Our Ref: 2022/040967
File No: R/2016/37/E
Your Ref: SSD-6966-MOD-3

Marcus Jennejohn
Senior Planning Officer
Department of Planning, Industry and Environment

Barangaroo Building R5 - SSD 6966 Mod 3 - Building Design Refinements - Advice on Modification

- 1. BBQ area
- 2. Indicative seating areas
- 3. Shelter
- 4. Paving on pedestals
- 5. Landscape area

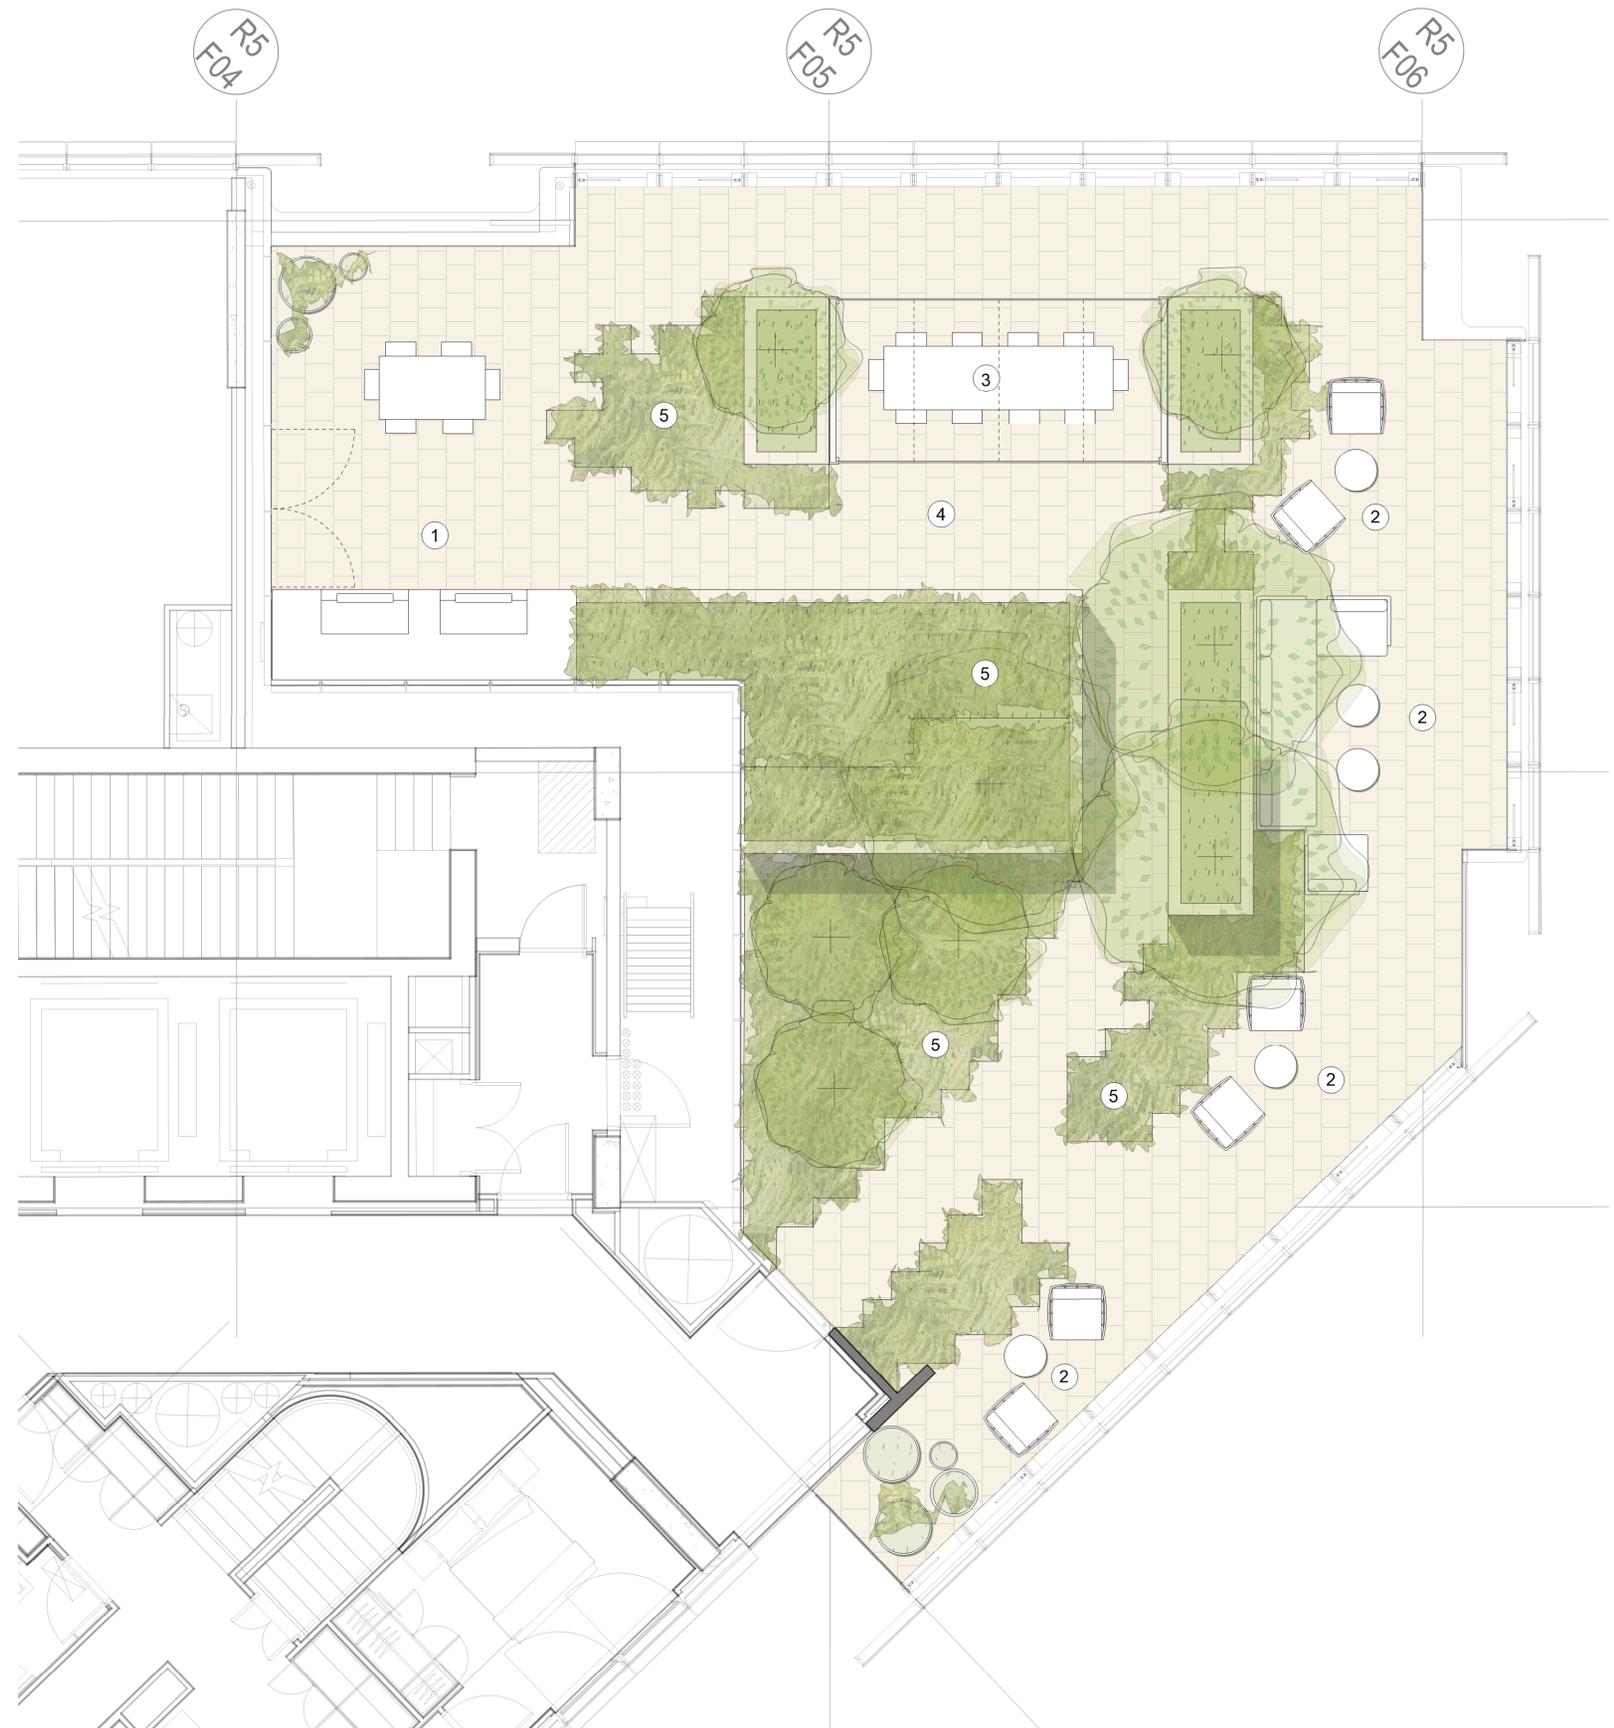
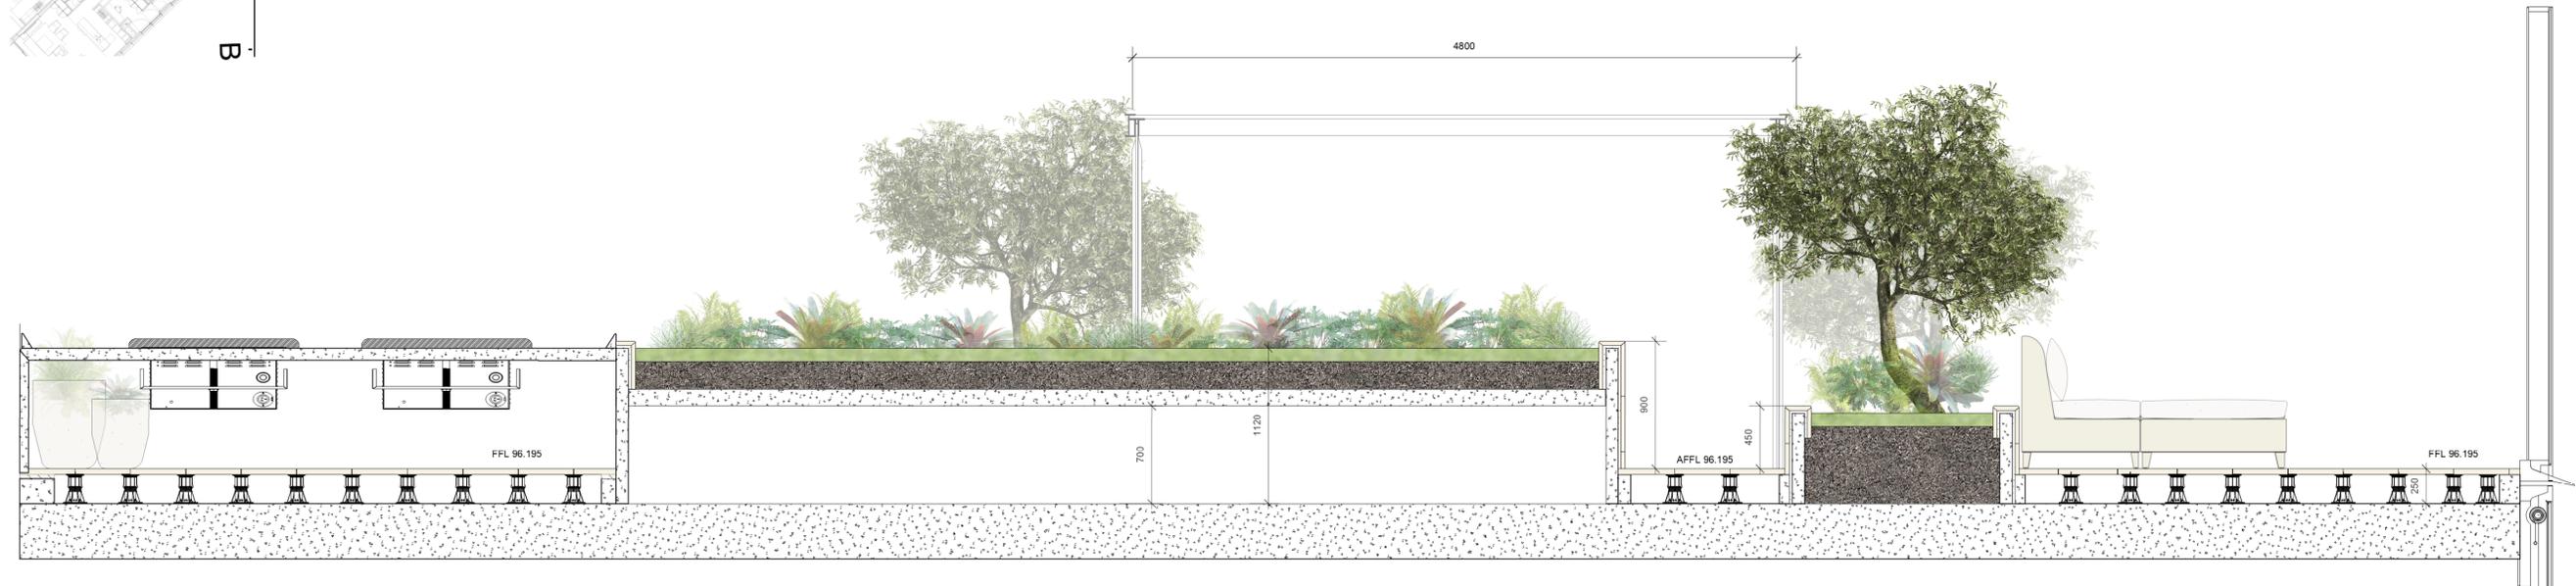
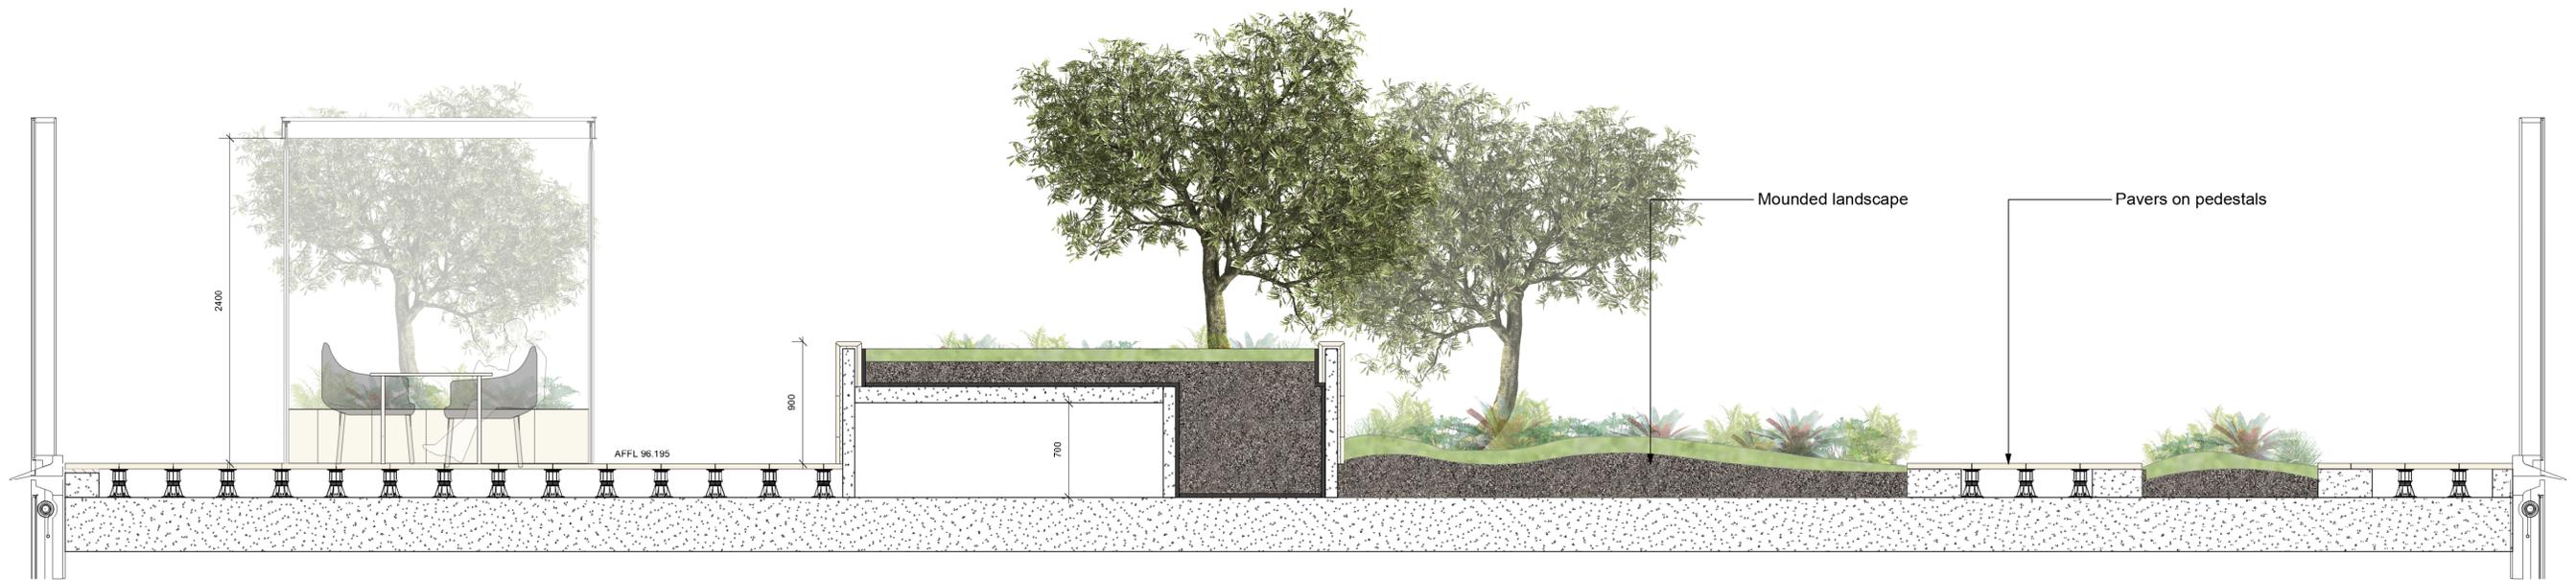
The City also notes the proposed design changes to the communal landscaped terrace including the provision of additional movable furniture. It is recommended that the plans include a notation, or a condition of consent be imposed requiring all furniture to be secured to avoid any damage caused by winds at Level 31.
